Your reference: SSD 5346; SSD 5347; SSD 5349
Our reference: ECM 3804935
Contact: Robert Craig
Telephone: (02) 4732 7593

State Significant Development Applications for Stages 2B and Stage 2C (SSD-5346), Stage 2D (SSD-5347) and Stage 3B (SSD-5349) of the North Penrith Mixed-Use Development.

Council officers have reviewed the Environmental Impact Statements and accompanying plans and reports submitted with the applications. Comments and recommended conditions of consent in relation to key assessment issues for the proposals are detailed in Attachment 1 to this letter.

**NORTH PENRITH**  
 STAGE 2D  
 TURNING PATHS

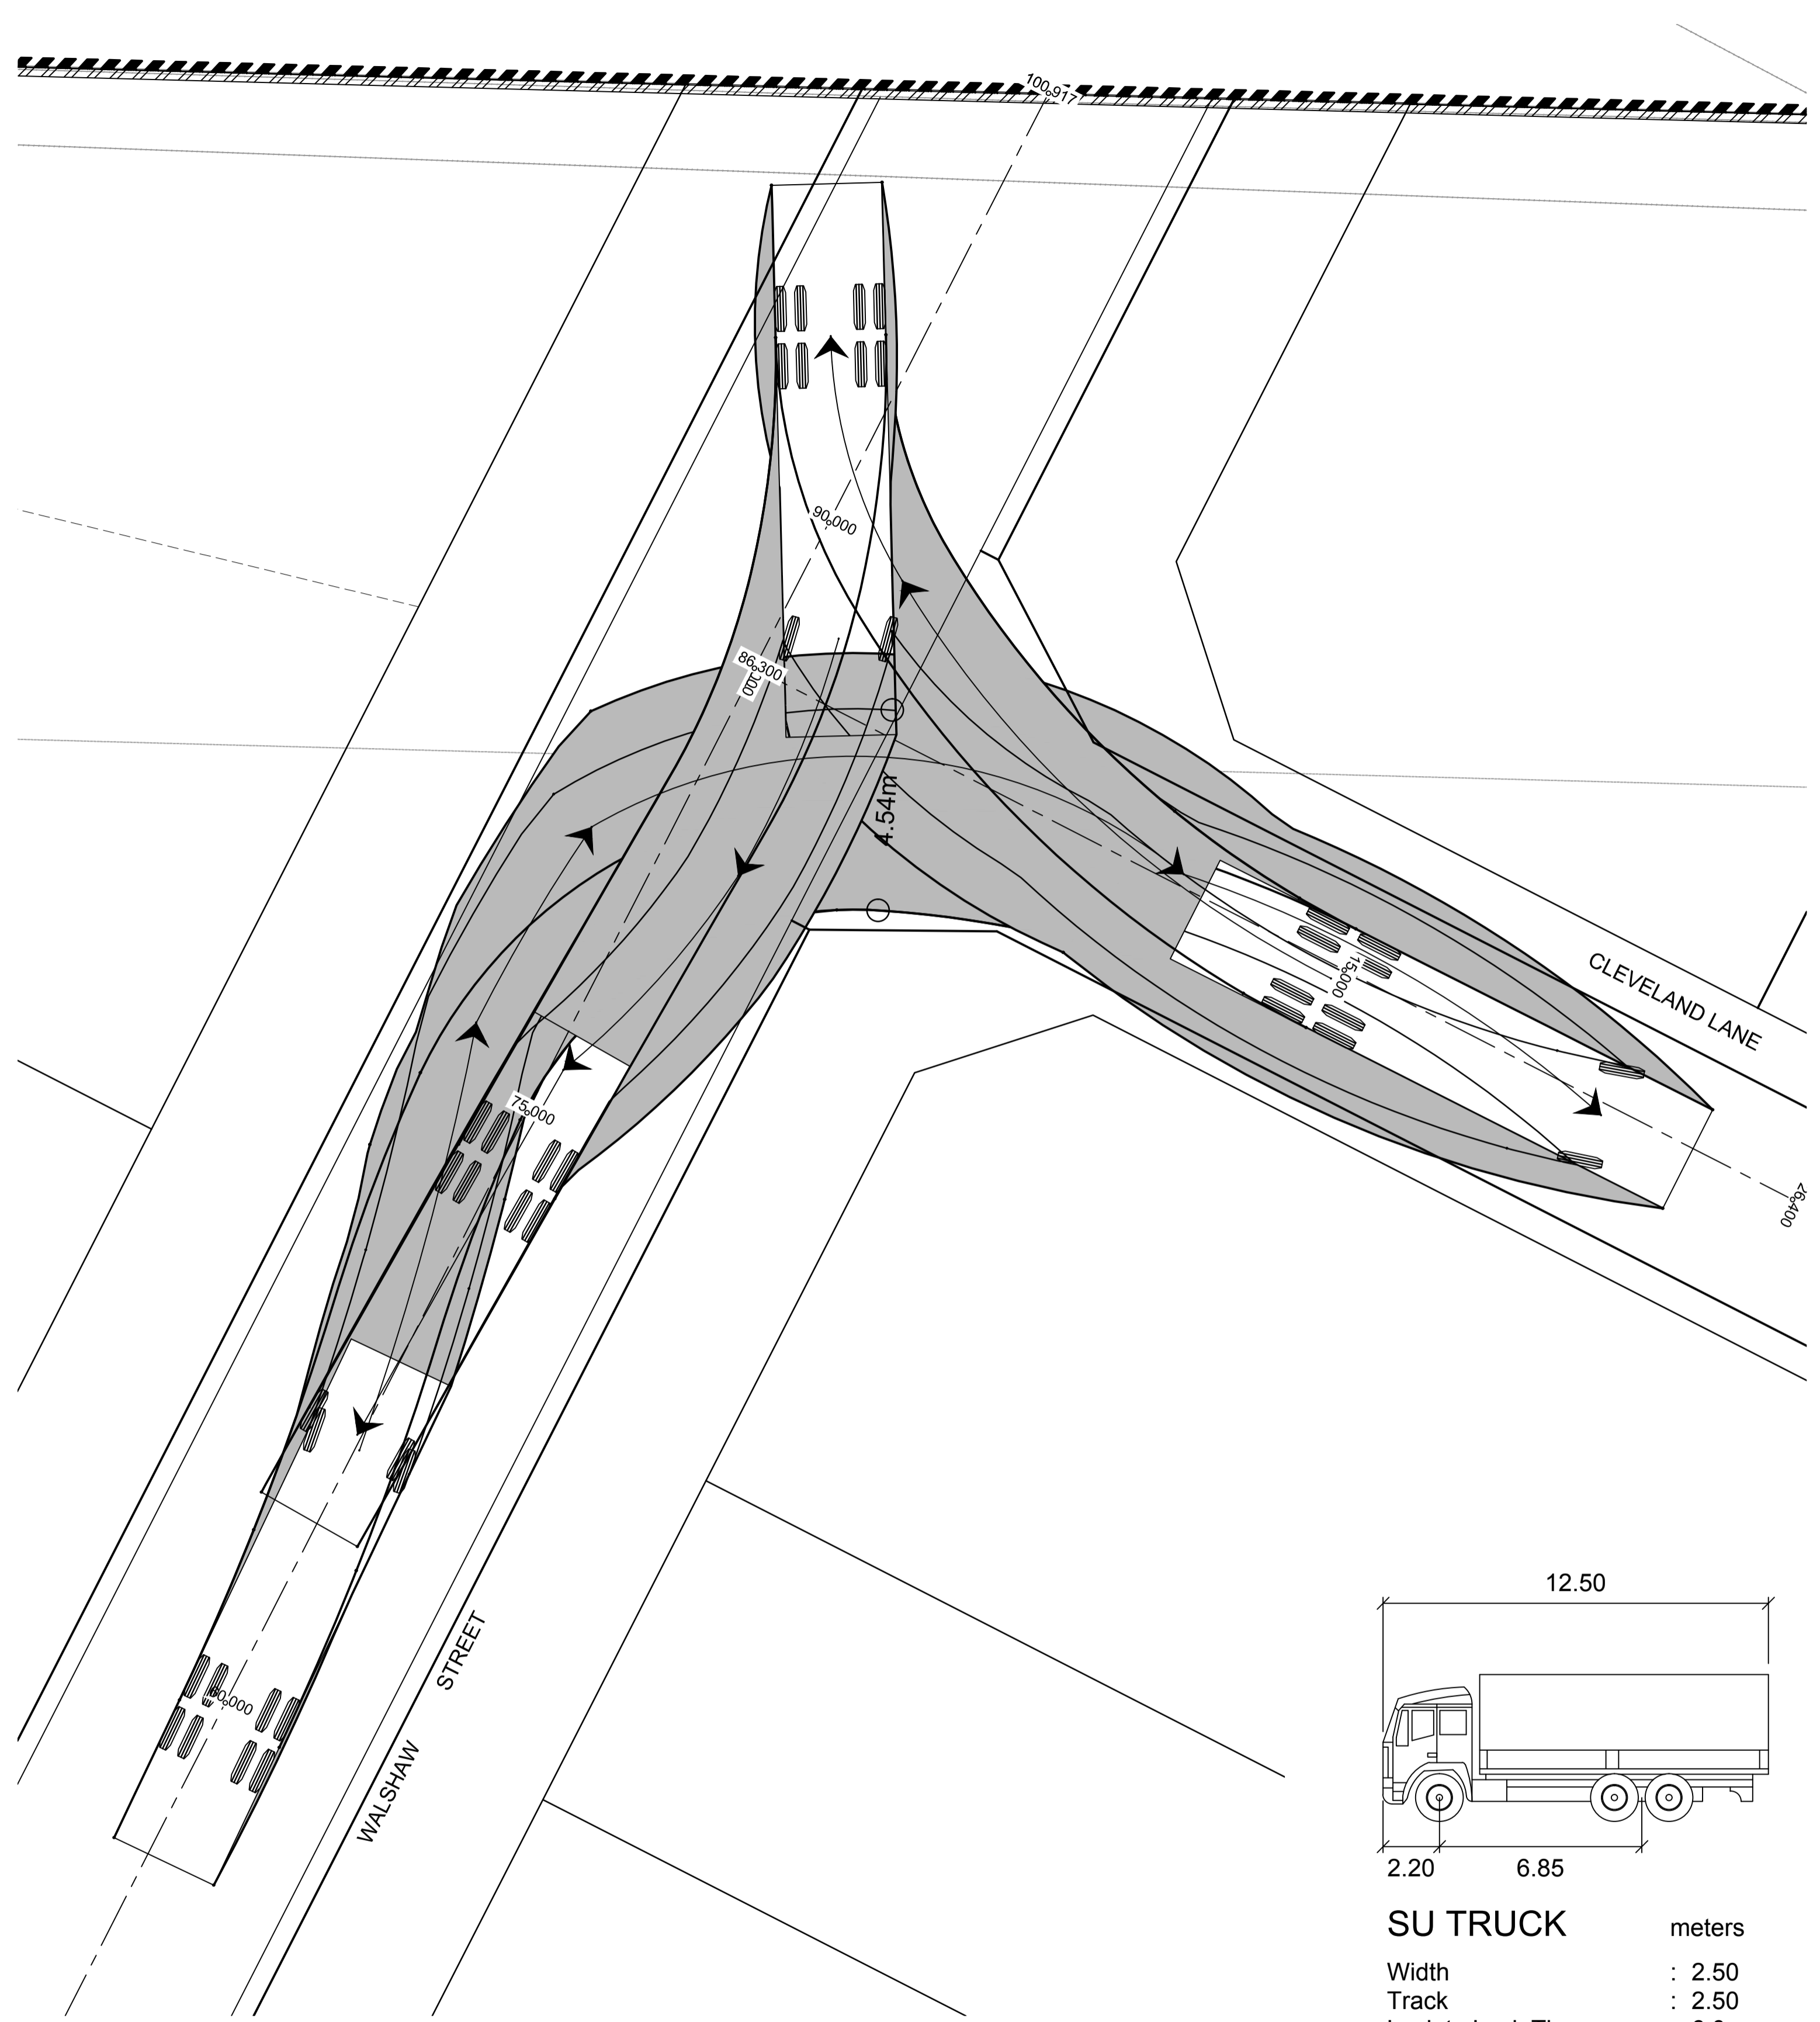
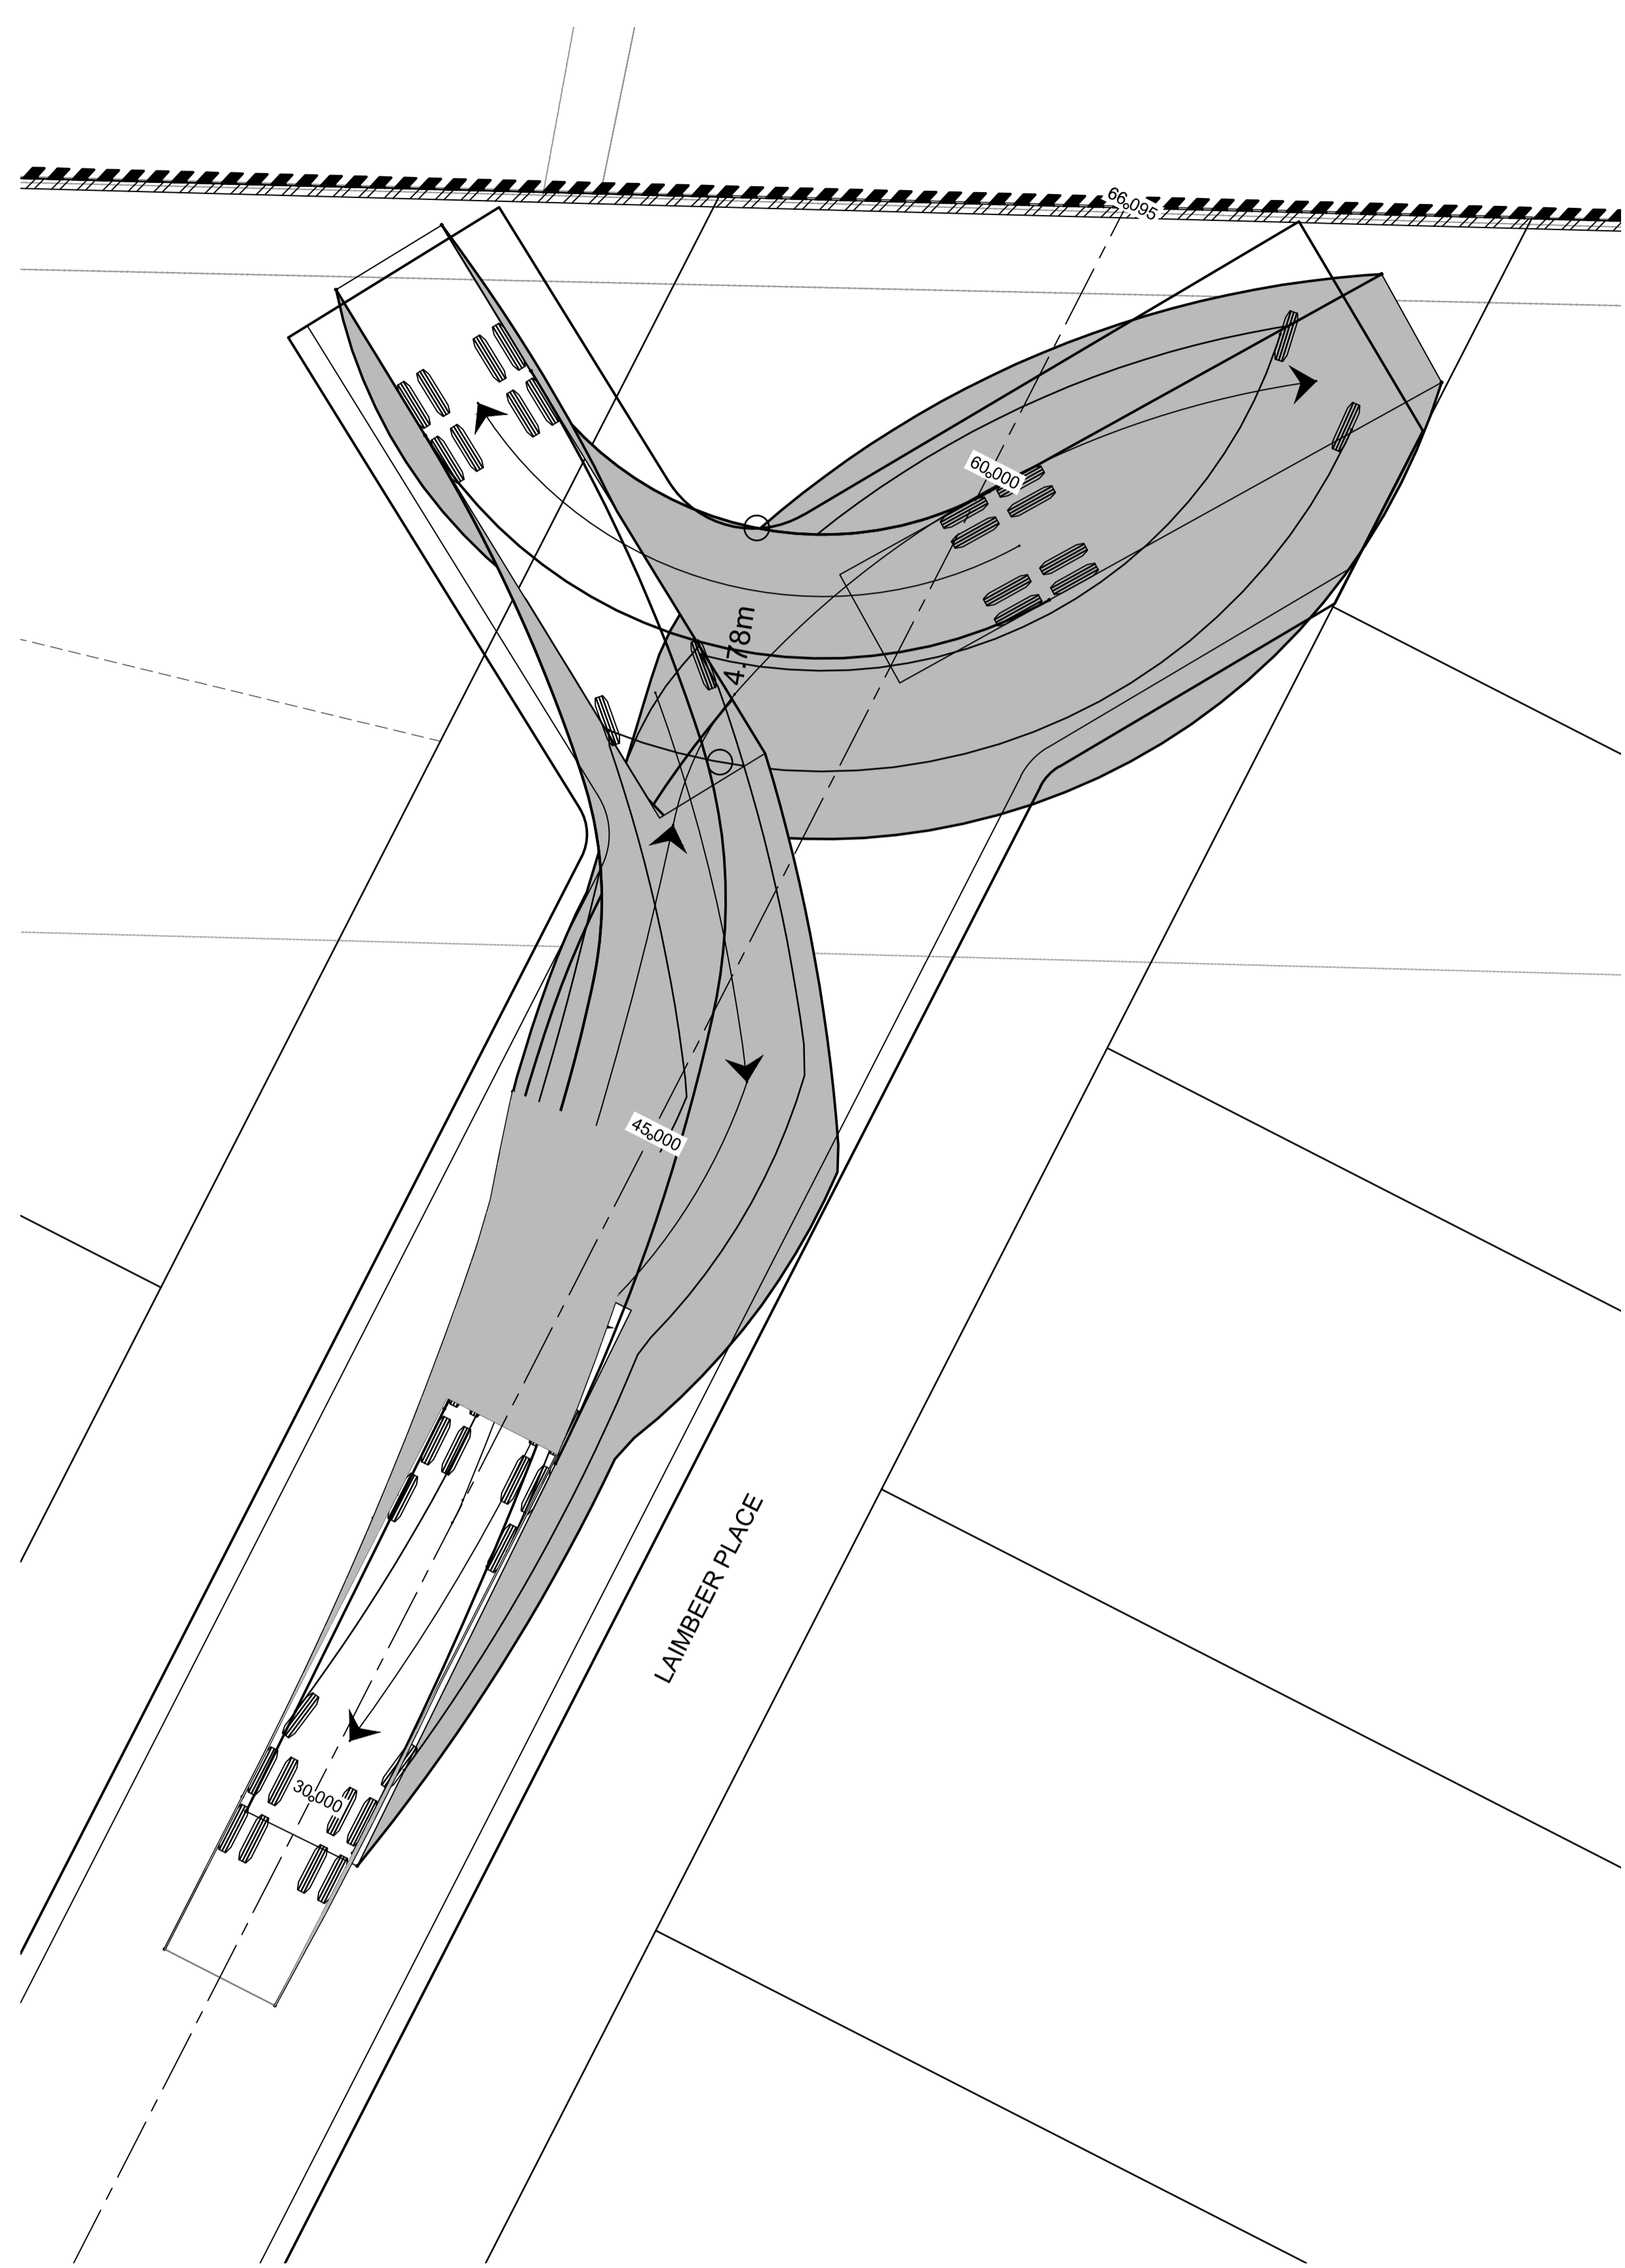
engineering details for approval. <u>Glass Elements</u> • Non-fading pigments and colours are to be fused into the glass. • Laminated toughened glass is to be used. • Access to replacement glass is to be available if required. • Replacement glass elements are to be made available in the original order. • All work health and safety issues are to be addressed. • All maintenance is to be carried out in a timely manner. • Before handover to Council, all public art works are to be inspected by Council officers for final sign off. Any maintenance required at this time is to be carried out by Landcom and the commissioned artists.
Waste Management	• In relation to future bin collection from in front of Lot 2327 Laimbeer Place, while turning circles for heavy rigid vehicles have been provided at the end of the street, a garbage truck may not be able to access bins if presented in front of this lot. The truck lifters are located near the cabin of the truck at the front left side meaning that the truck may not be able to reverse back to a point to access the bins.
